RE: Shoreline Exemption (SX-26-00008 Roe) – Deemed Incomplete – Request for Additional Information

Kittitas County Community Development Services (CDS) received your Shoreline Exemption application (SX-26-00008 Roe) on May 11, 2026, for Parcel 351834. Staff has reviewed your application and determined that more information is needed before this application can be processed any further. As such, Kittitas County declares your application **incomplete** as of May 26, 2026.

**STEVEN ROE**  
**HABITAT MANAGEMENT PLAN**

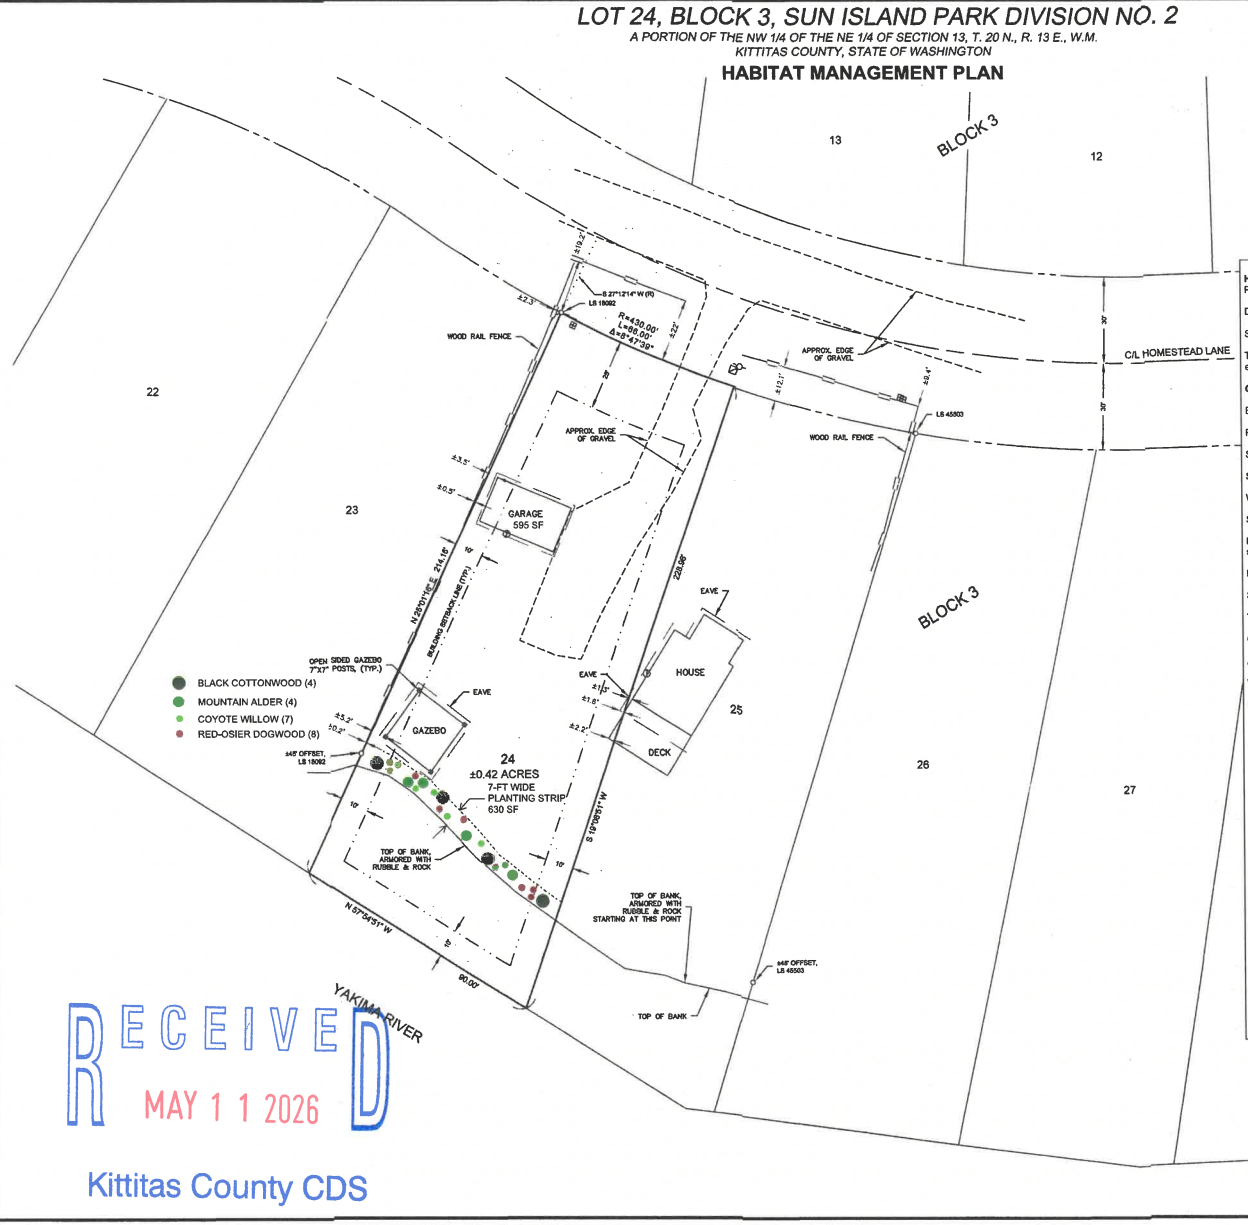
1. Please provide an updated site plan showing proposed uses & their distances from the Ordinary High-Water Mark of the Shoreline body of water. This component is required per the listed requirements on the front of the Shoreline Exemption application.
